## Building Inspections - Re: 205allenavenue

**From:** Building Inspections  
**To:** Wayne Nelsen  
**Date:** 6/24/2013 9:31 AM  
**Subject:** Re: 205allenavenue

A-3 CONVERT MASTER BEDRM TO UNIT #4	
SCALE: 1/4"=1'-0"	APPROVED BY:
DATE: 6-25-2013	DRAWN BY: MRO
205 ALLEN AVE.	
SHEET 3 OF 3	
DRAWING NUMBER: 2013-06

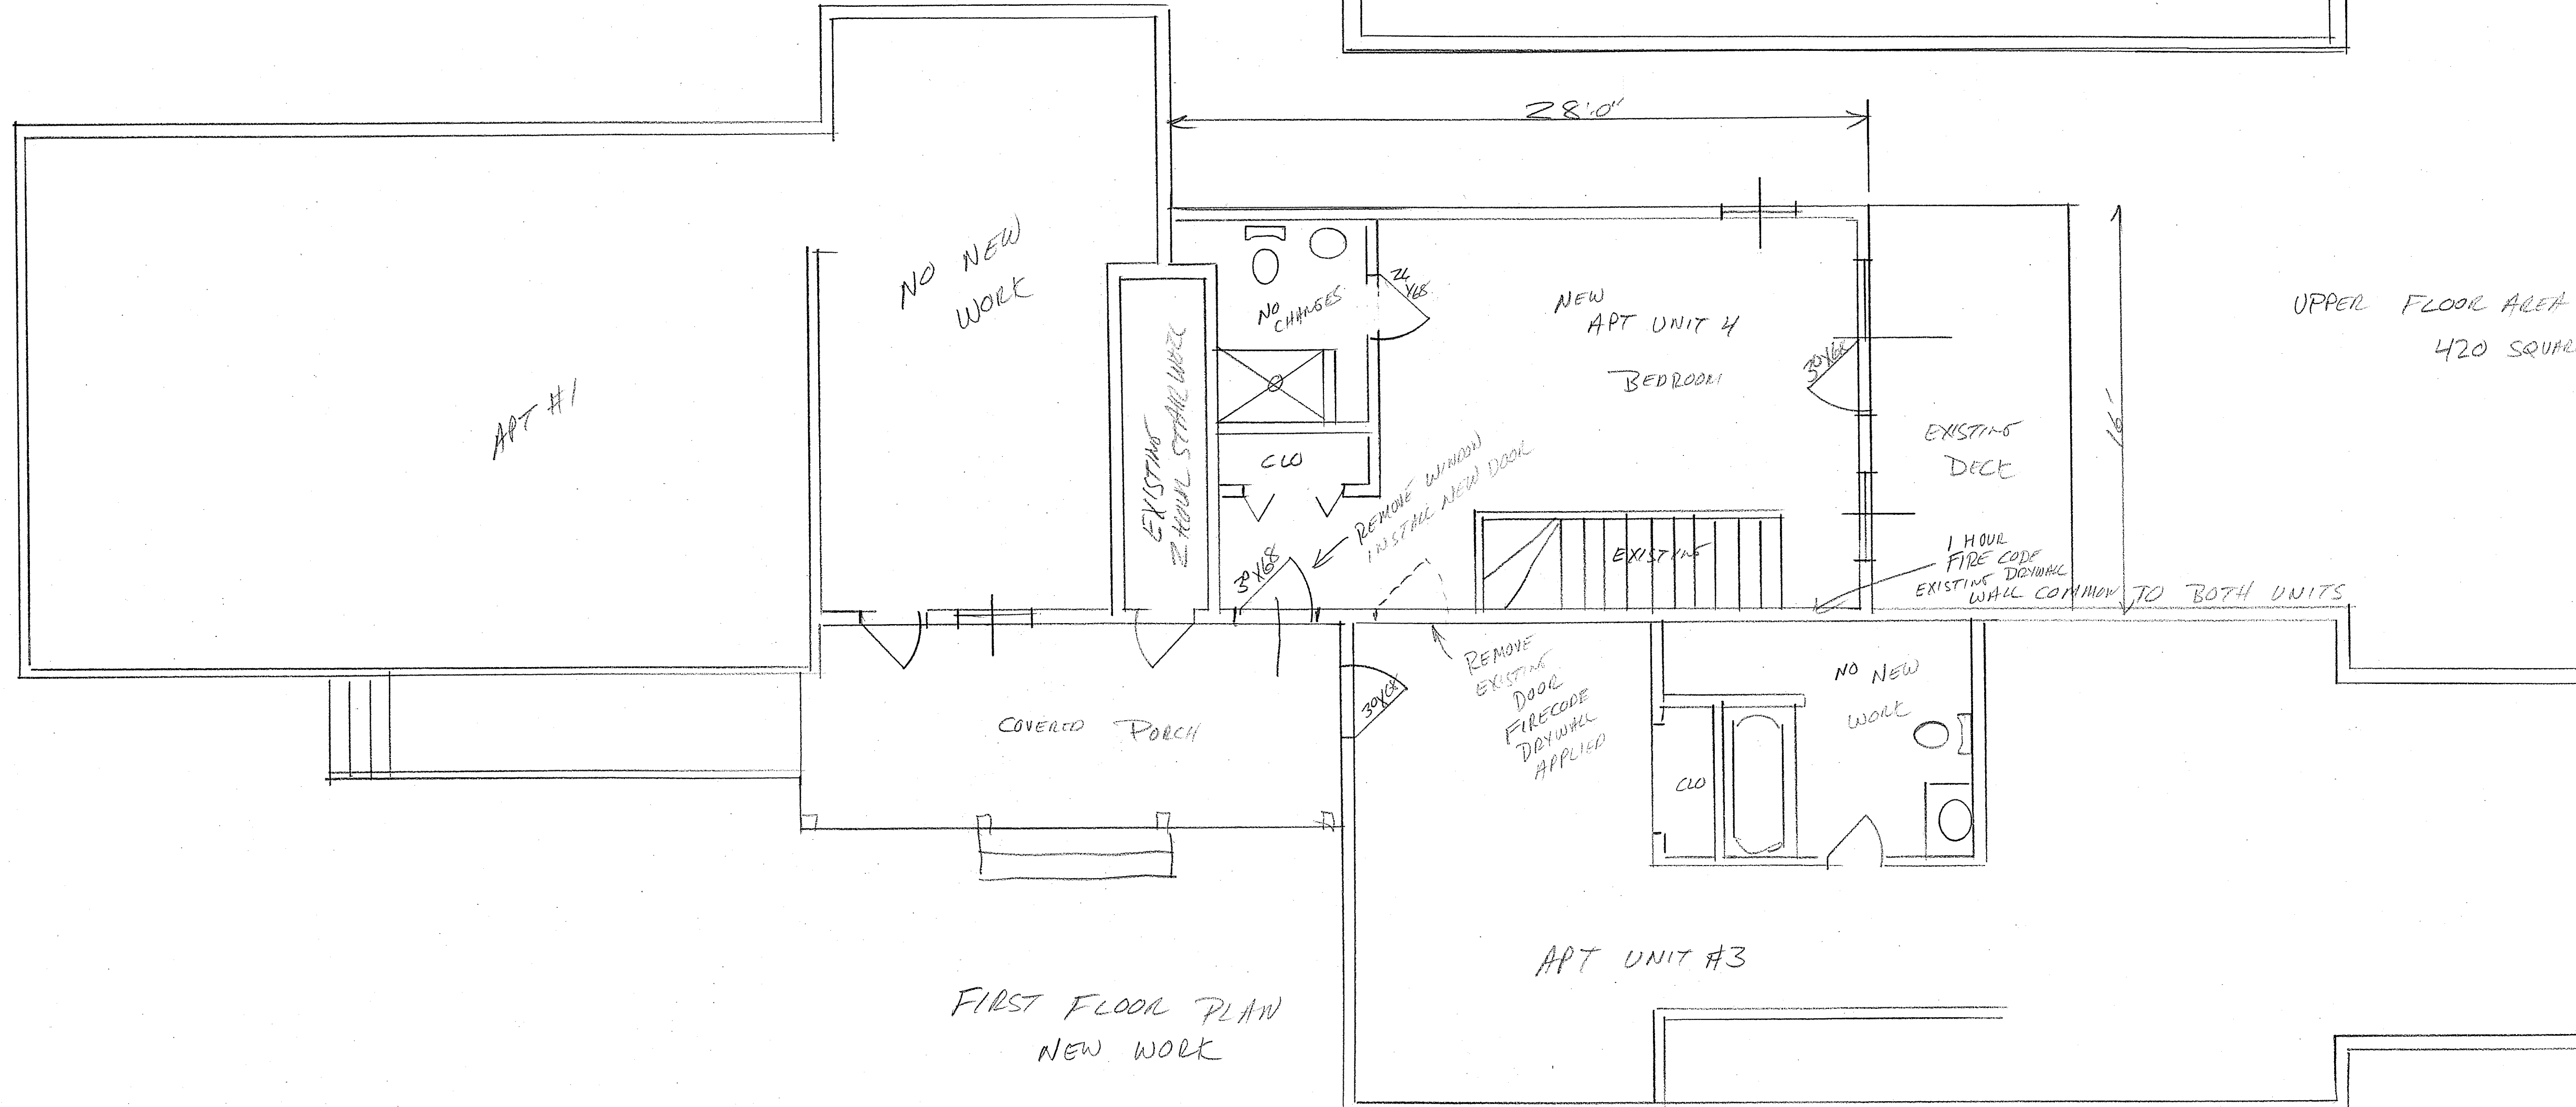
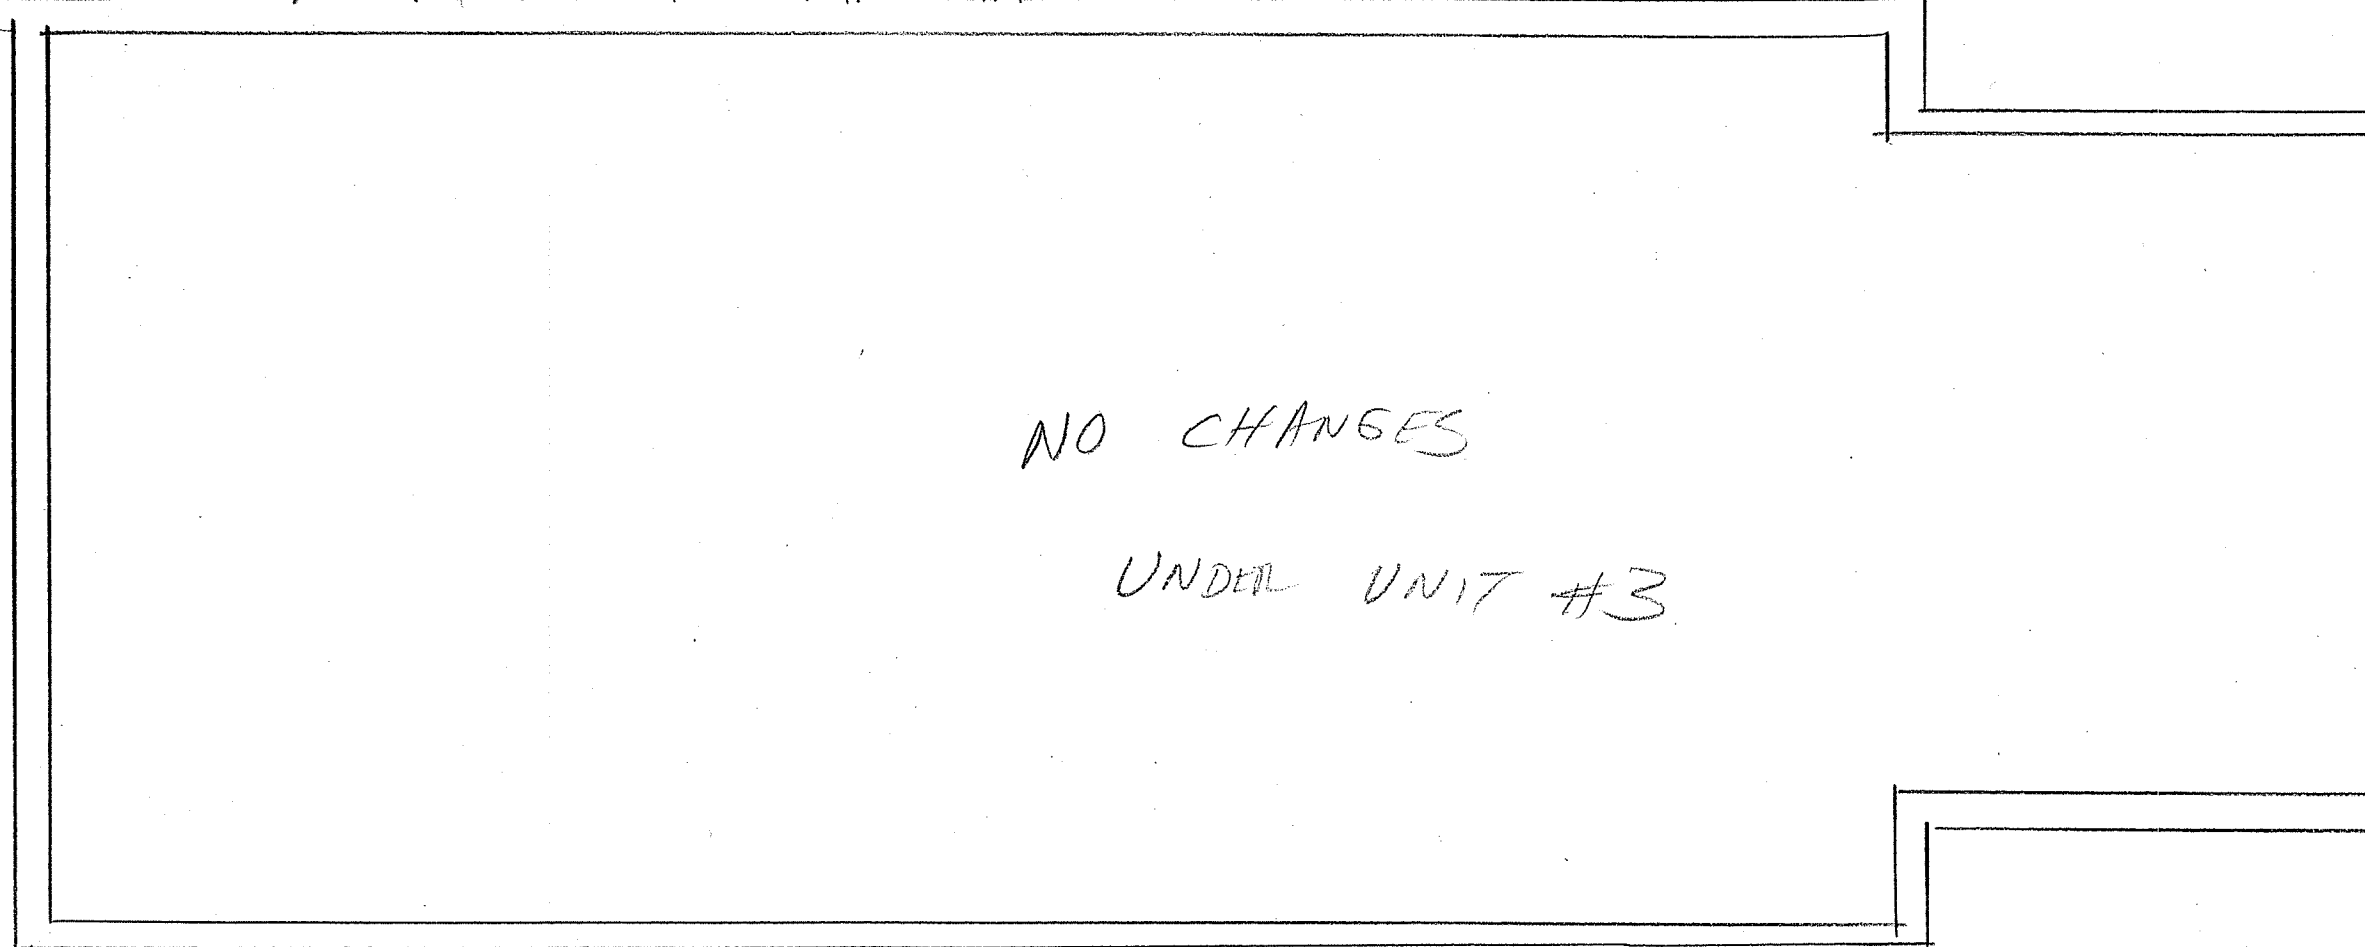
Wayne, we have tried to contact you regarding incomplete application materials. It looks like you are trying for a change of use from 3 unit to a 4. Also, there are no structural drawings with dimensions for these changes. We do have an opportunity for you to come in and sit down with a plan reviewer, with plans in hand, and go over the expectations and develop an appropriate application. If you would like to schedule one of these plan reviews, please call 874-8703 and request one.
